From: Laura Gibbons
Sent: 14 May 2019 10:23
To: Planning.Responses
Cc: Amber Willard
Subject: RE: Planning Consultation on: AW/114/19/HH

Engineers Comments Regarding Surface Water Drainage

Site Address: 20 Tenmore Gardens, Aldwick

Description of Works: Two storey side extension and single storey rear extension

SITE PLAN - scale 1:500

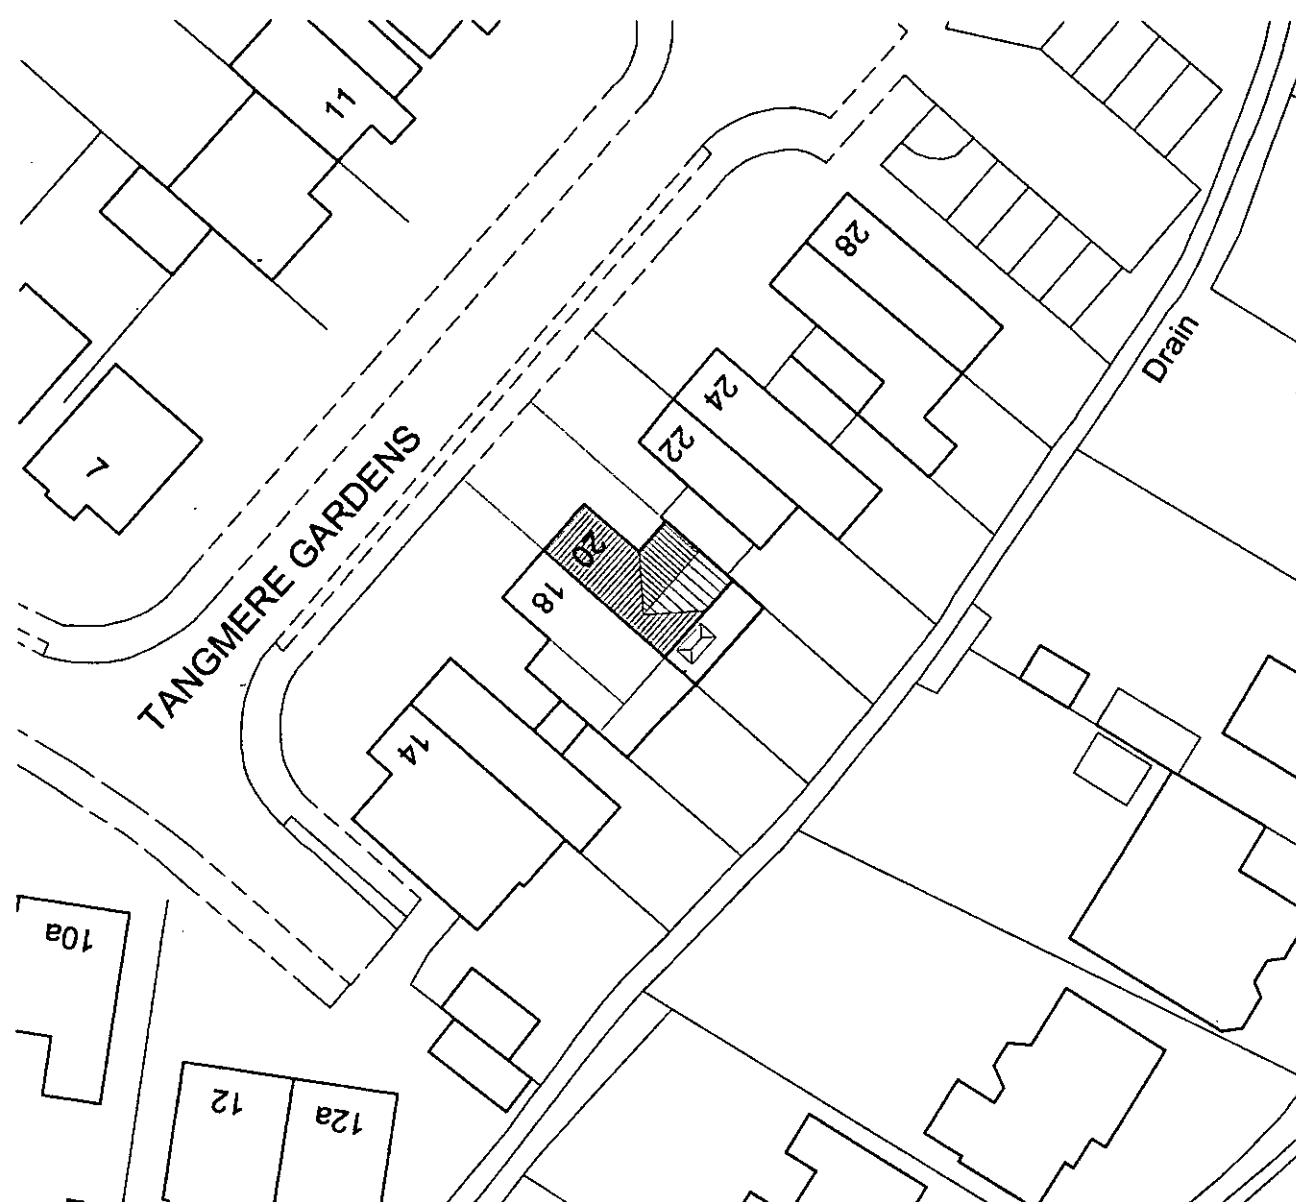
There is an ordinary watercourse along the property boundary. Development should be kept away from this watercourse. Surface water drainage must follow the hierarchy for sustainable drainage with infiltration fully investigated.

The development layout must take account of any existing watercourses (open or culverted) to ensure that future access for maintenance is not restricted. No development is permitted within 3m of the bank of an ordinary watercourse, or 3m of a culverted ordinary watercourse.

"Development shall not commence, other than works of site survey and investigation, until full details of the proposed surface water drainage scheme have been submitted to and approved in writing by the Local Planning Authority. The design should follow the hierarchy of preference for different types of surface water drainage disposal systems as set out in Approved Document H of the Building Regulations, and the recommendations of the SuDS Manual produced by CIRIA. Winter groundwater monitoring to establish highest annual ground water levels and winter Percolation testing to BRE 365, or similar approved, will be required to support the design of any Infiltration drainage. No building / No part of the extended building shall be occupied until the complete surface water drainage system serving the property has been implemented in accordance with the agreed details and the details so agreed shall be maintained in good working order in perpetuity."

"The development shall not proceed until details have been submitted to and approved in writing by the Local Planning Authority for any proposals: to discharge flows to watercourses; or for the culverting, diversion, infilling or obstruction of any watercourse on or adjacent to the site. Any discharge to a watercourse must be at a rate no greater than the pre-development run-off values. No construction is permitted, which will restrict current and future land owners from undertaking their riparian maintenance responsibilities in respect to any watercourse or culvert on or adjacent to the site."
